DOC17/291337-2
SSD 5144 MOD 5

Mandalong Southern Extension Project - Modification 5 (SSD 5144 MOD 5)

ATTACHMENT A: OEH REVIEW OF THE STATEMENT OF ENVIRONMENTAL EFFECTS - PROPOSED MODIFICATION 5 OF THE MANDALONG SOUTHERN EXTENSION PROJECT (SSD 5144 MOD 5)

**Figure 2: Assessment Circles**

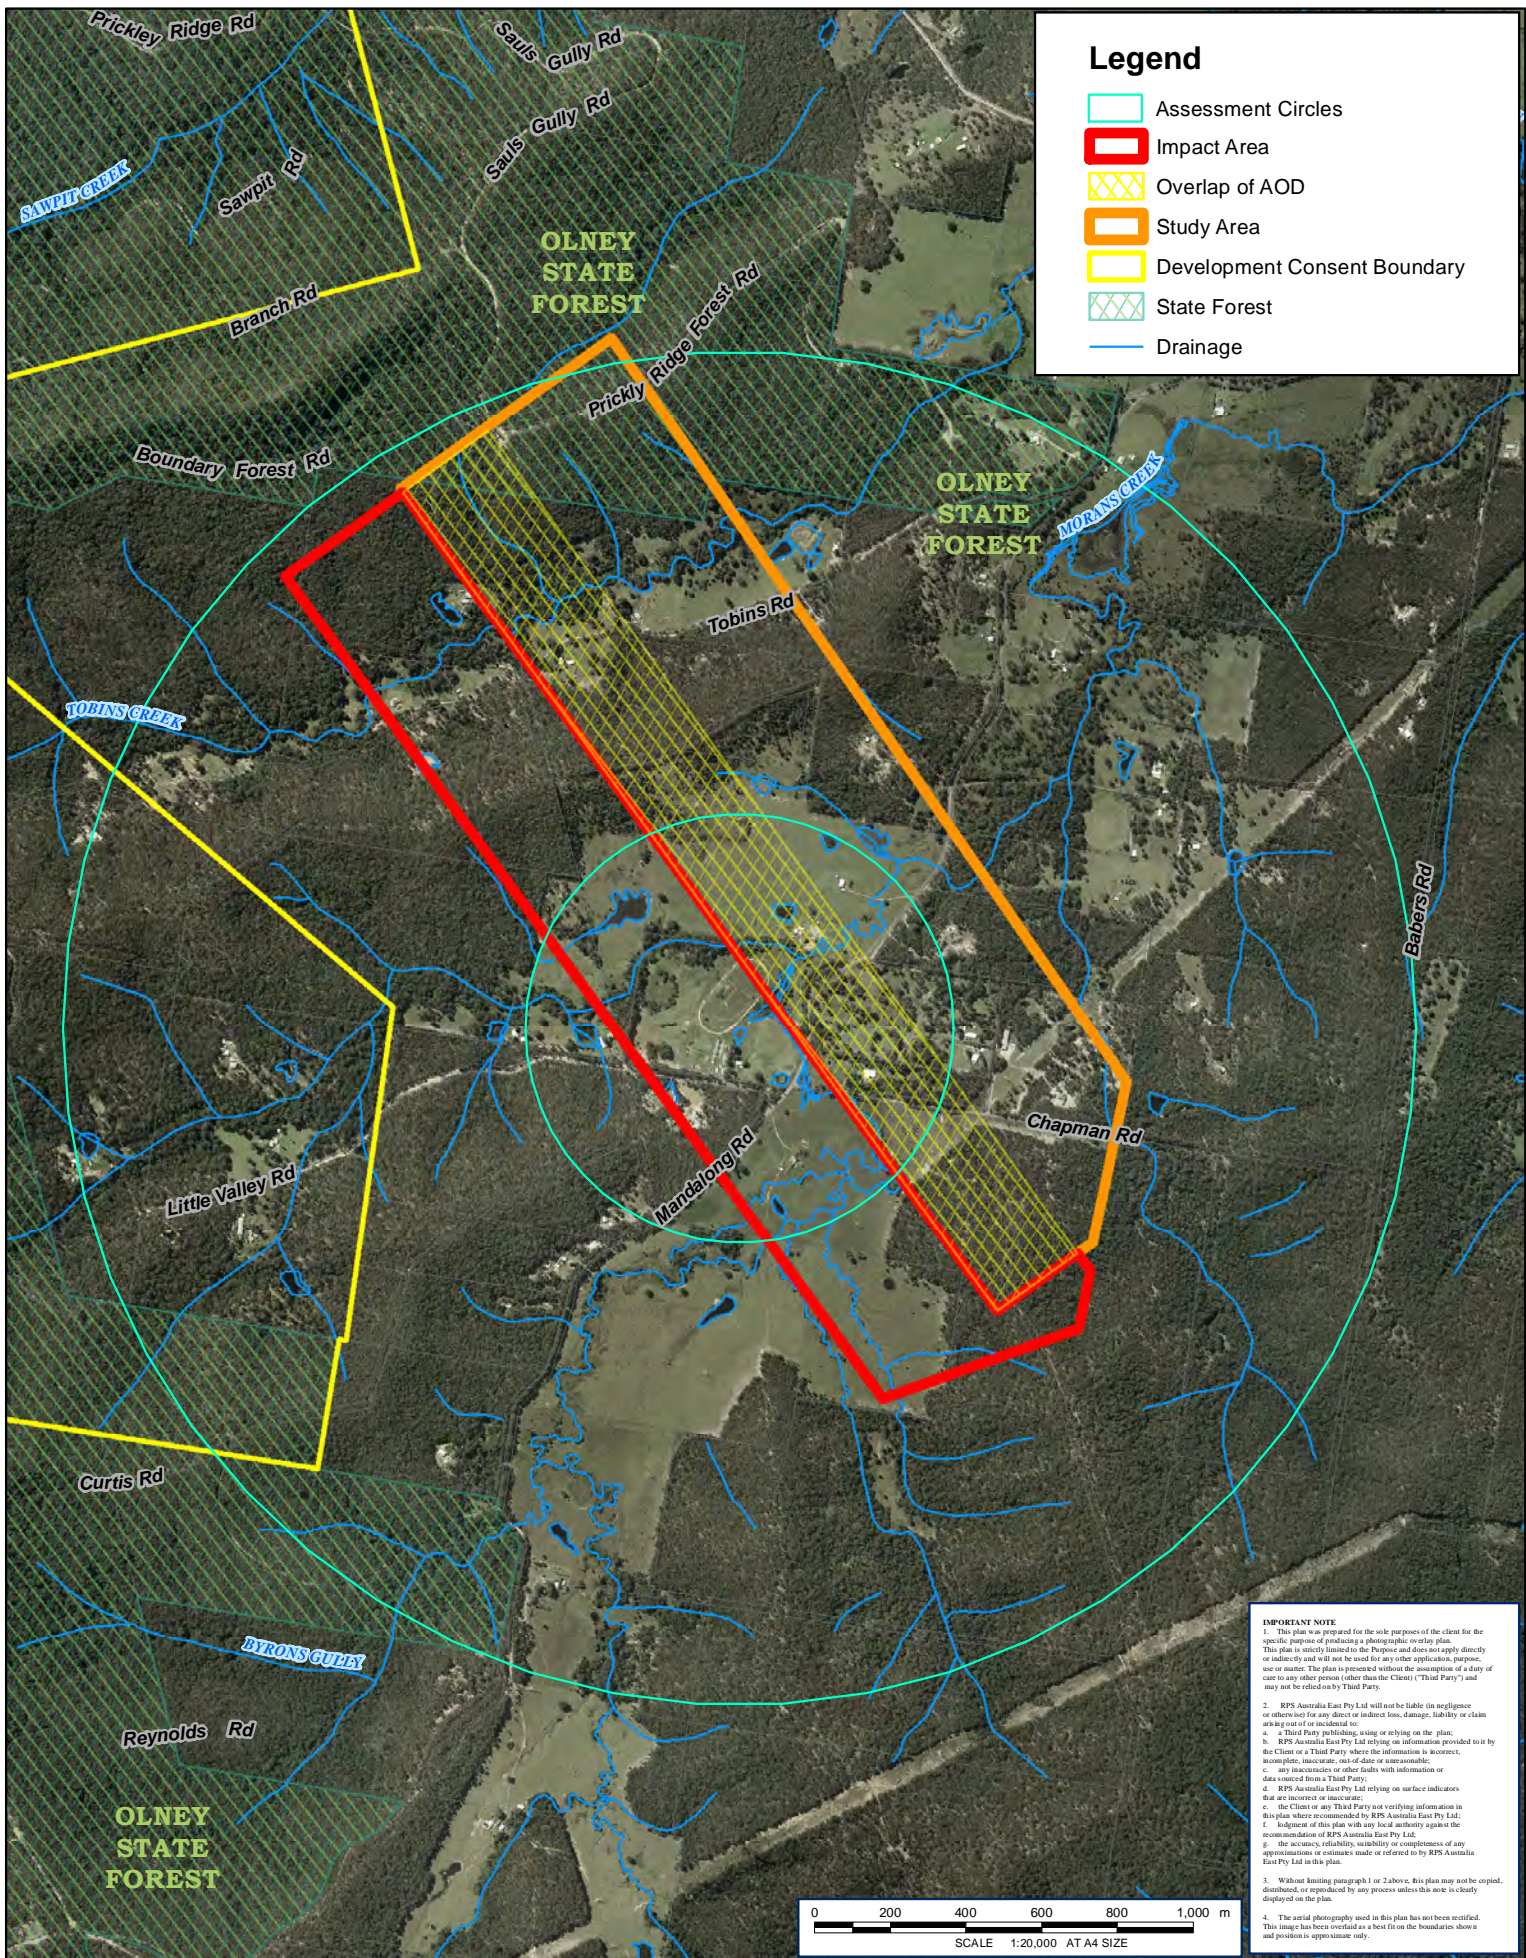
As a minor point, OEH notes that the 'Impact Area' (outlined in red in Figure 1 to 5 inclusive) considered in this assessment does not appear to include the proposed extension of longwall panel 24. Ecological and ponding data is provided for that extension area, and given it is within the Study Area it has been included in the FBA assessment.
